**From:** [Downes, Scott G \(DFW\)](#)  
**To:** [Kelly Bacon \(CD\)](#)  
**Cc:** [Torrey, Elizabeth M \(DFW\)](#)  
**Subject:** RE: SE-22-00005 Haase - Notice of Application  
**Date:** Tuesday, March 15, 2022 9:28:19 AM

**Subject:** SE-22-00005 Haase - Notice of Application

CDS is requesting comments on the following SEPA application: SE-22-00005 Haase. Links to the file materials can be found below. The comment period will end Friday, March 25, 2022 at 5pm. CDS will assume your agency does not wish to provide comment if not received by this date. Links to the file materials can be found below. Please contact me directly with any questions or issues accessing the materials.

SITE PLAN

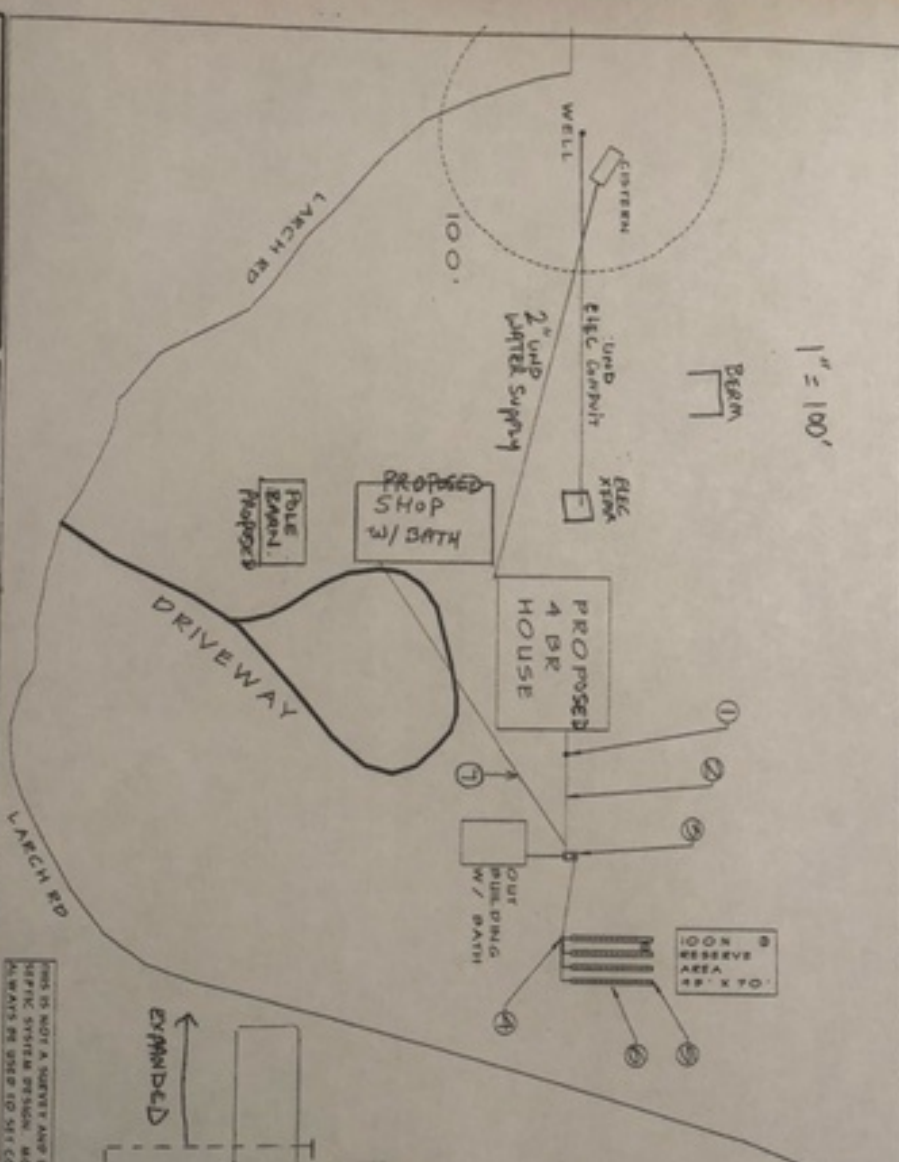
To follow up on this, there are streams on both the western and eastern ends of this property. Their site plan would need to be set back from these streams per the CAO requirements. The stream on the western edge is a Ns stream, non-fish bearing seasonal stream and on the eastern end is a disconnected portion of the North Fork Teanaway river and associated shoreline area.
